Final Report - Corrections Required **Application No. LUPL-25-0008**

Document Filename : 241010_BLR Village C Land Use Plan.pdf

BANNING LEWIS RANCH - VILLAGE C
LAND USE PLAN
COLORADO SPRINGS, CO
LAND USE PLAN

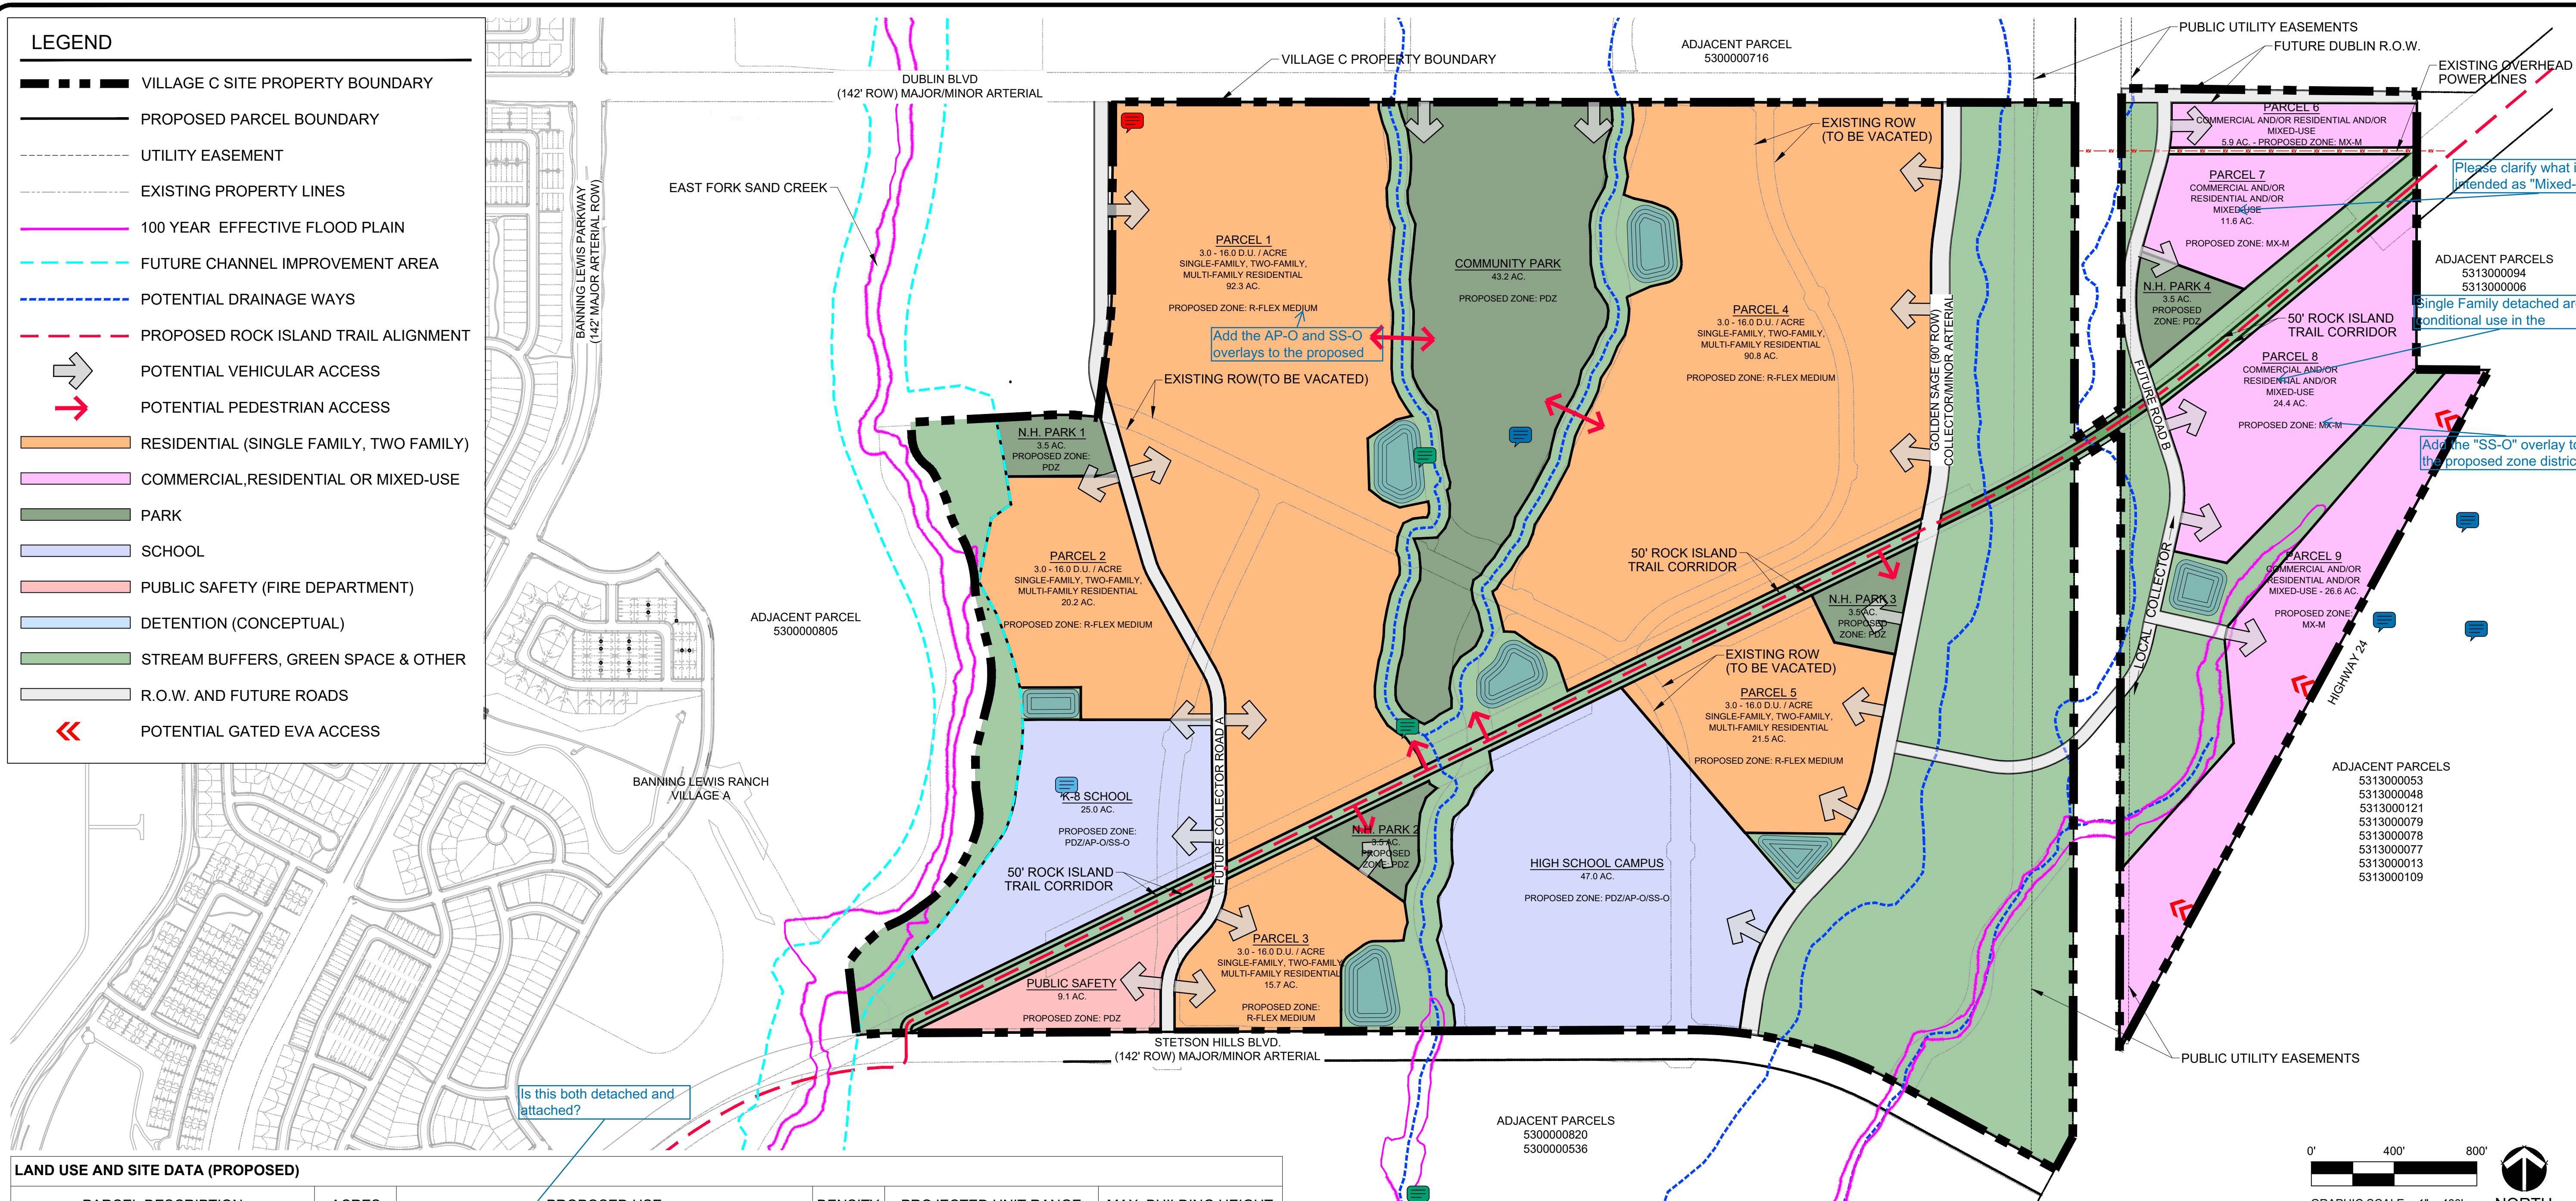
Comment ID	Page Reference	Reviewer : Department	Review Comments
9	1	Erica Schmitz : City Engineering - SWENT	The existing channel must be shown and labeled and if the existing channel is not stabilized, it may be required to be stabilized. Please reach out to the Lead Reviewer to set-up a meeting to discuss the channel improvements and to schedule a site visit.
10	1	Erica Schmitz : City Engineering - SWENT	Add a note calling out channel improvement requirements associated with the Site, including responsible party, long-term maintenance responsibility, and timing requirements. If not applicable, provide a note stating channel improvements are not required.
11	1	Erica Schmitz : City Engineering - SWENT	Info Only: Please contact the Lead Reviewer, Erica Schmitz (erica.schmitz@coloradosprings.gov) with any questions related to SWENT comments. Please reference the Planning review number in all communications.

Comment ID	Page Reference	Reviewer : Department	Review Comments
16	2	Caroline Miller : Planning	Informational - More Parks comments or edits are likely to be requested.
19	2	Caroline Miller : Planning	Please revise all proposed zones - PDZ for Parks and Schools is no longer proposed.
21	2	Caroline Miller : Planning	As shown, there is a need for pedestrian bridges to allow connection to the Community Park site. Will the developer provide those?
22	2	Caroline Miller : Planning	As communicated with the developer team, May 2025, BLR Village A is to be viewed as a separate development, removing the Community obligation of Village A from Village C. Please remove all references to Village A acreage. PLDO reviewer acknowledges that with this direction, the Community Park size is required to meet B2 & C obligations is 28.7 acres, though additional acreage would be supported in creating a larger, more versatile site, and better meeting Community Park Site characteristics.

23	2	Caroline Miller : Planning	Please add Village B2 Community Park acreage to table, as it is carried over from Village B2.
24	2	Caroline Miller : Planning	Please recalculate math for Community Park obligations for Village C and B2. Reviewer calculates 11.568 for Village C and 17.128 for Village B2 with units shown.
26	2	Caroline Miller : Planning	Please confirm, in prior LUP Review (PDZL-24-0005) 1,841 units were used as an average for PLDO calculations. Now, this number has been revised to 1,446 to account for 6 du/ac (Note 1) where the mean unit count is now 2,285. Please confirm with staff which count is more accurate. Typically staff would go with average.
28	2	Caroline Miller : Planning	Notes 2 and 4 need to be updated with accurate acreages and reflect that Village A is no longer included.
29	2	Caroline Miller : Planning	Staff sees 4 3.5 acre parks totaling 14 acres of Neighborhood Parks. Are there any notes that need to be added regarding the 4th park site considering future multifamily development? Is the intent that the future multifamily development will be meeting Neighborhood Park PLDO through this dedication, with Community Park fees in lieu due? Staff is supportive of the eastern 4th park site, as it is geographically separate from the rest of Village C and a benefit to the residents there.

32	2	Allison Stocker : Planning	Label creek name and type
42	2	Tamara Baxter : Planning	Refer to EPC, EPC Engineering and District 49 comments which were uploaded to file.
43	2	Tamara Baxter : Planning	Please see separate email dated 6.25.25 from City Budget Office sent separately.
44	2	Tamara Baxter : Planning	Single Family detached are conditional use in the MX-M zone district.
45	2	Tamara Baxter : Planning	Please clarify what is intended as "Mixed-Use", does this anticipate more than commercial and residential per UDC?
46	2	Tamara Baxter : Planning	Add the AP-O and SS-O overlays to the proposed zone district labels.
47	2	Tamara Baxter : Planning	Add the "SS-O" overlay to the proposed zone district labels
49	2	Tamara Baxter : Planning	Is this both detached and attached?
50	2	Tamara Baxter : Planning	This range does not include the proposed residential density in parcel 6, 7, 8 and 9.
52	2	Tamara Baxter : Planning	The UDC does not define Mixed-Use. Can you please clarify. Does this encompass the uses that are allowed or conditional in the MX-M zone district? Are there uses that you want to restrict?

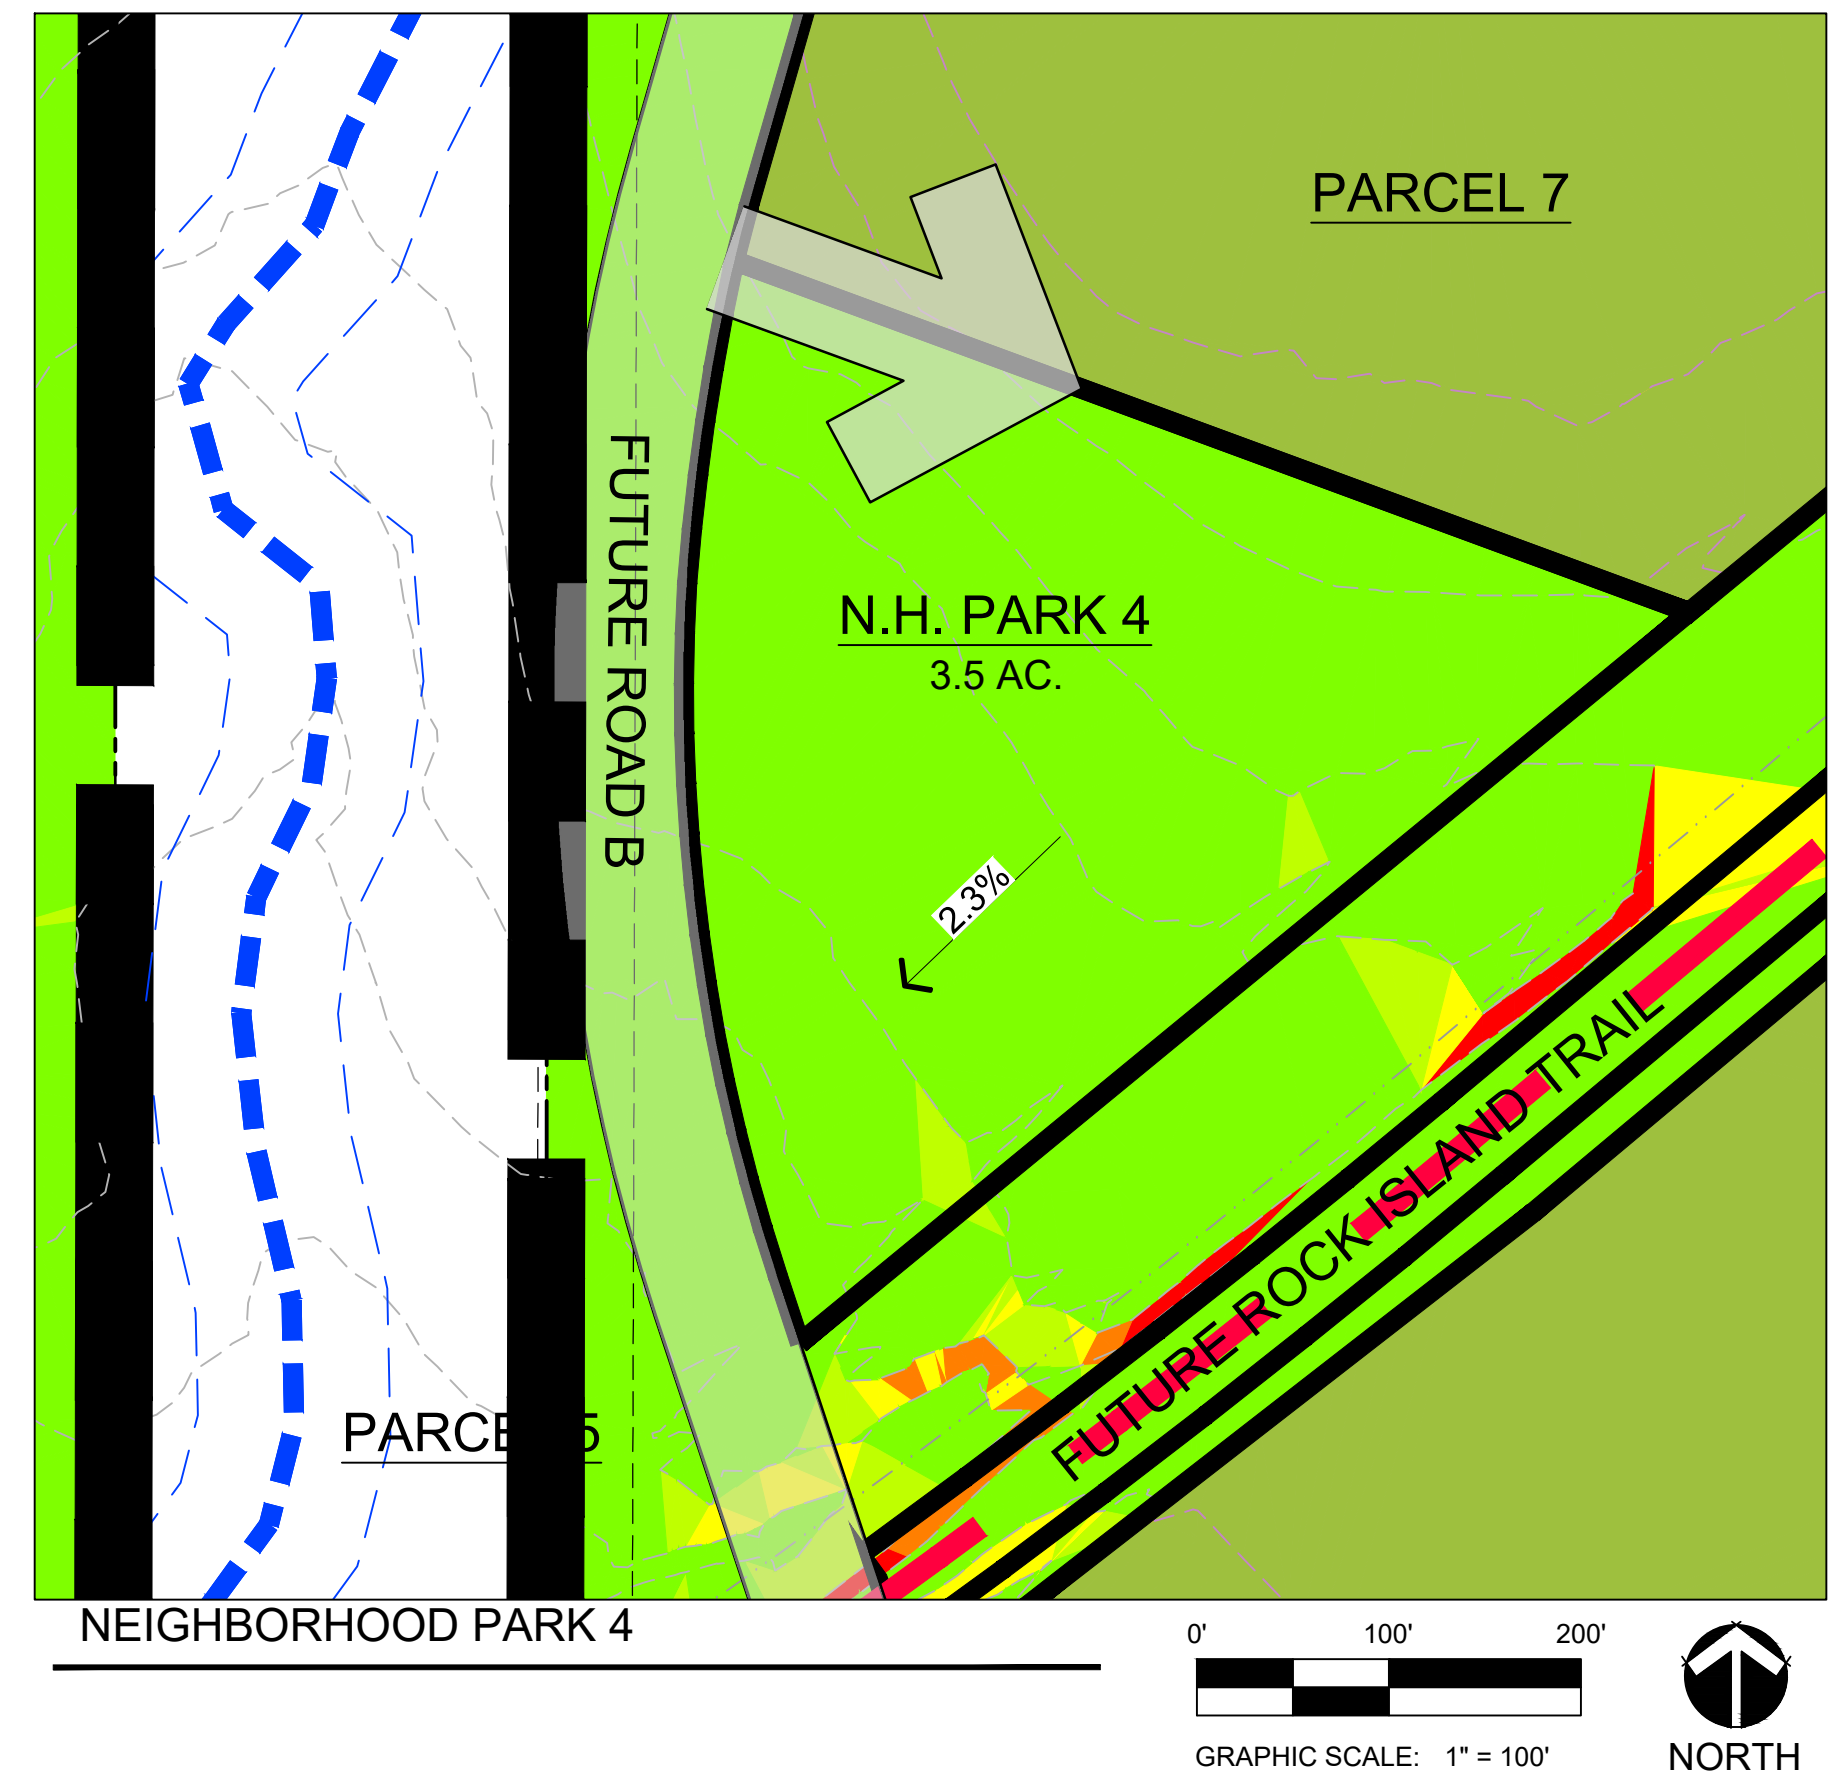
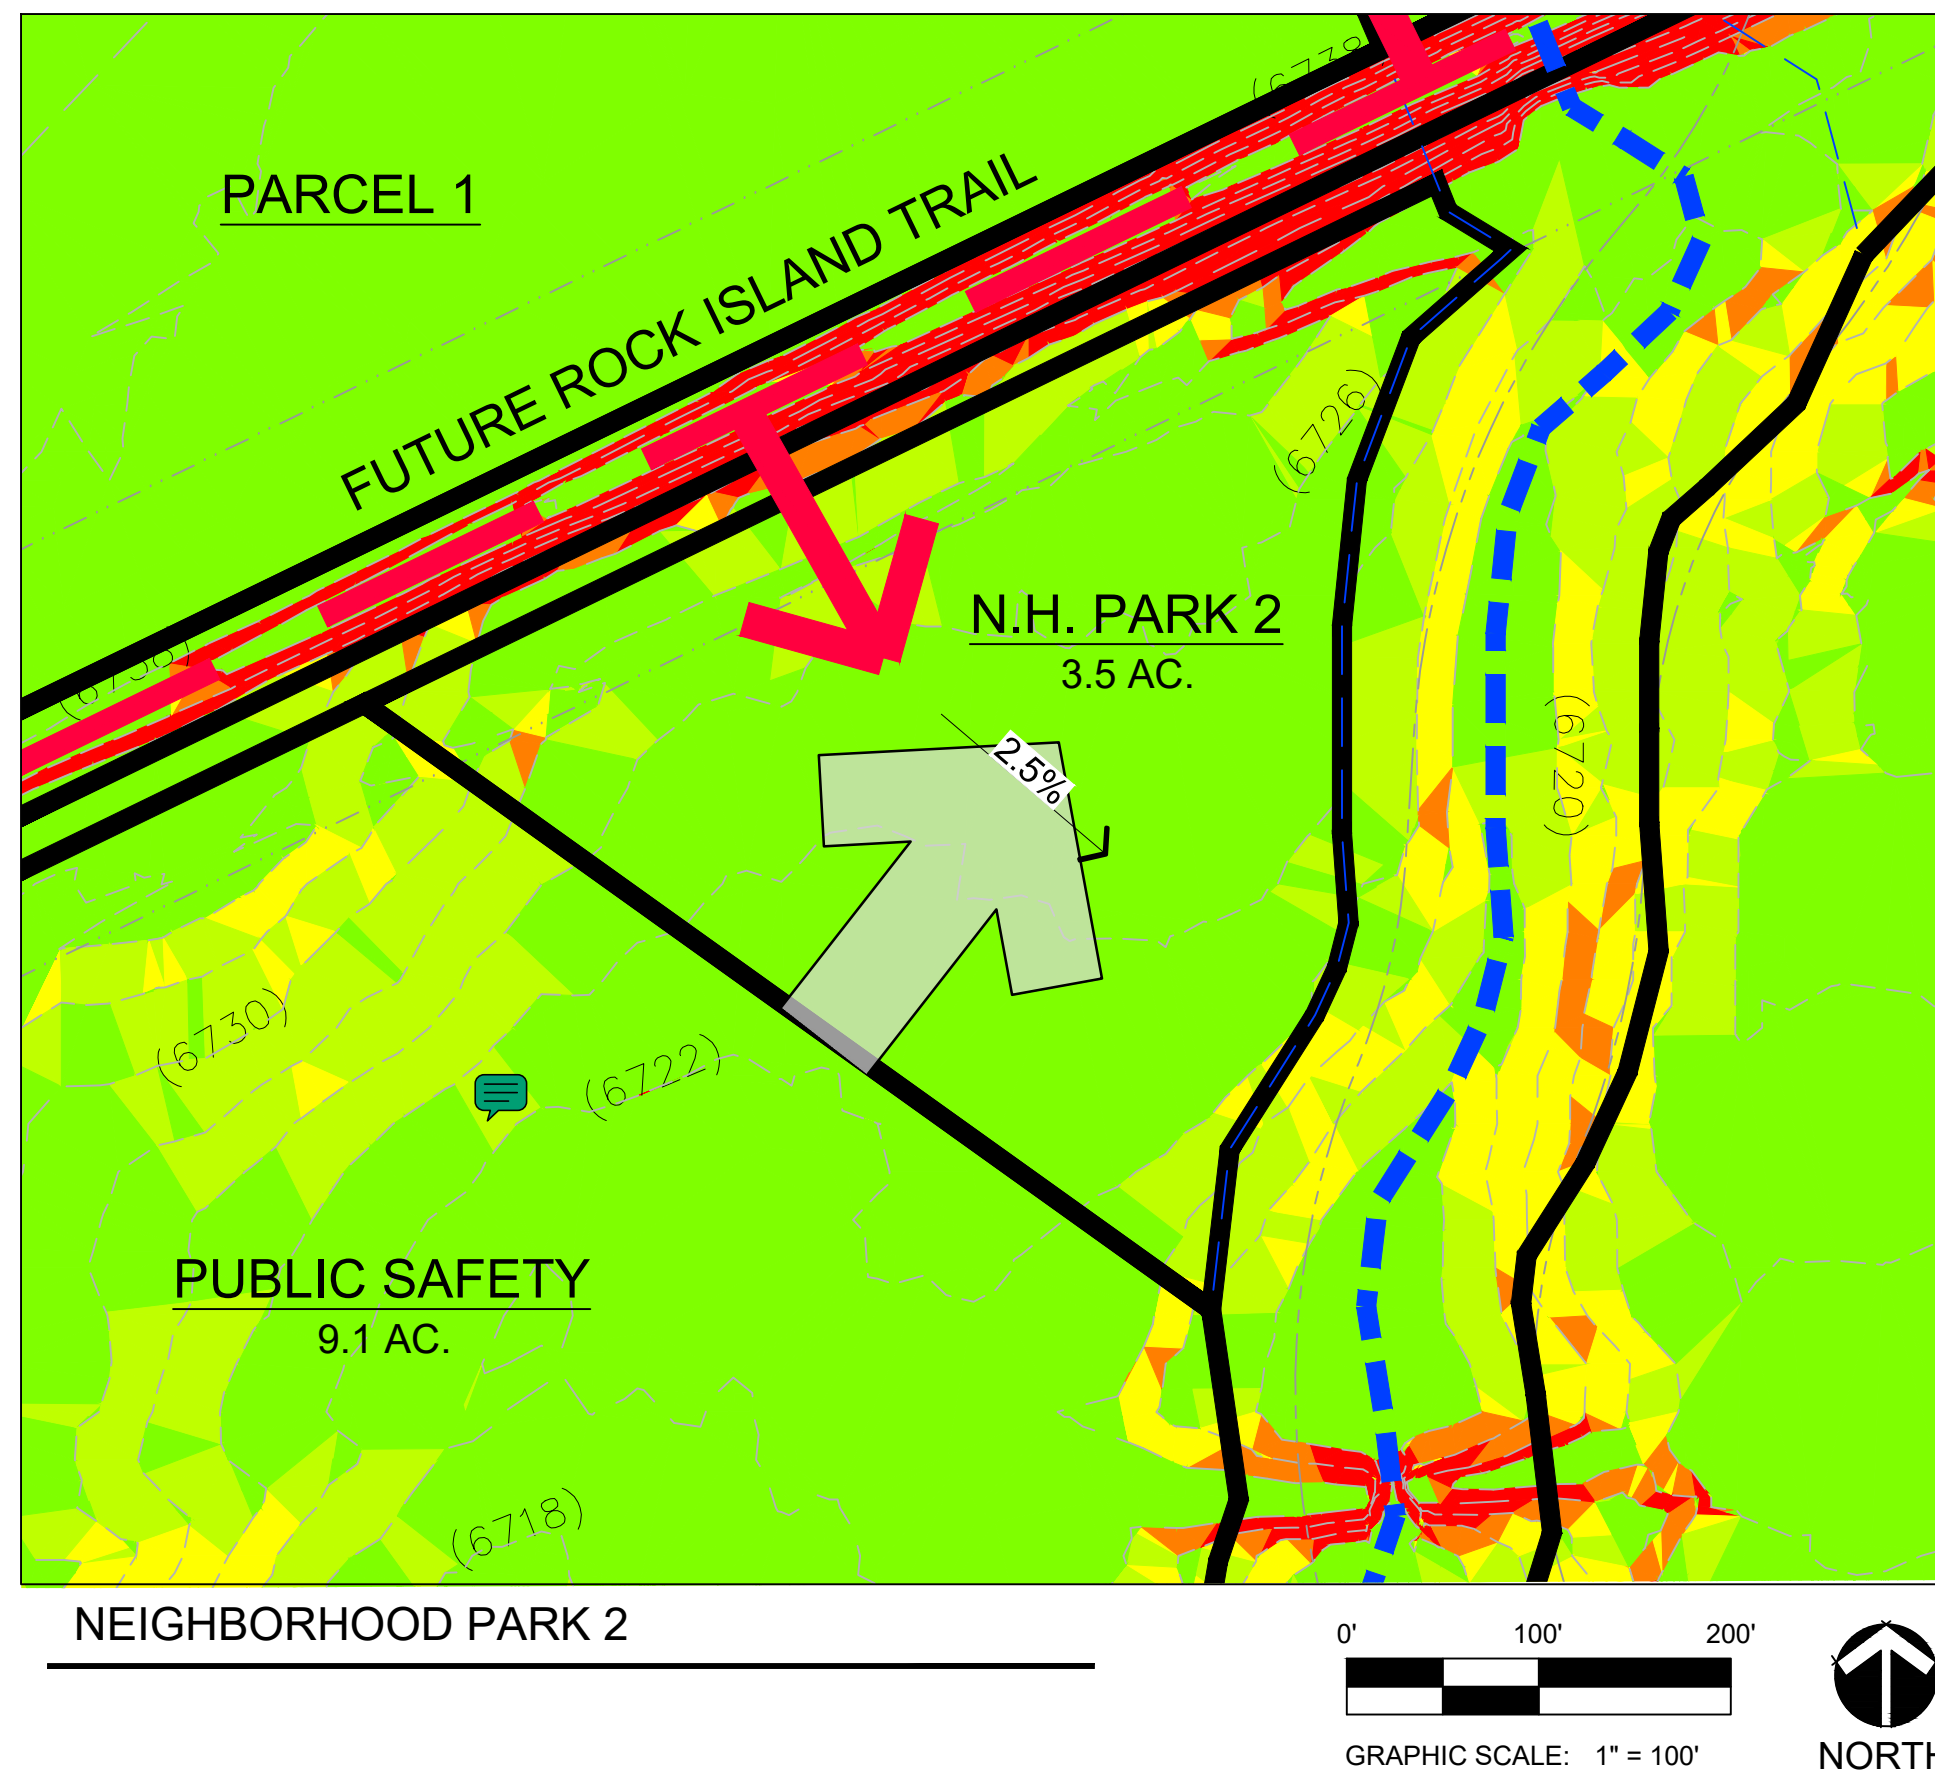
53	2	Tamara Baxter : Planning	Please use this on the coversheet as well.
54	2	Tamara Baxter : Planning	What does this residential encompass?
30	3	Caroline Miller : Planning	This graphic doesn't match the LUP Bubbles shown on page 2, park is not next to Public Safety.
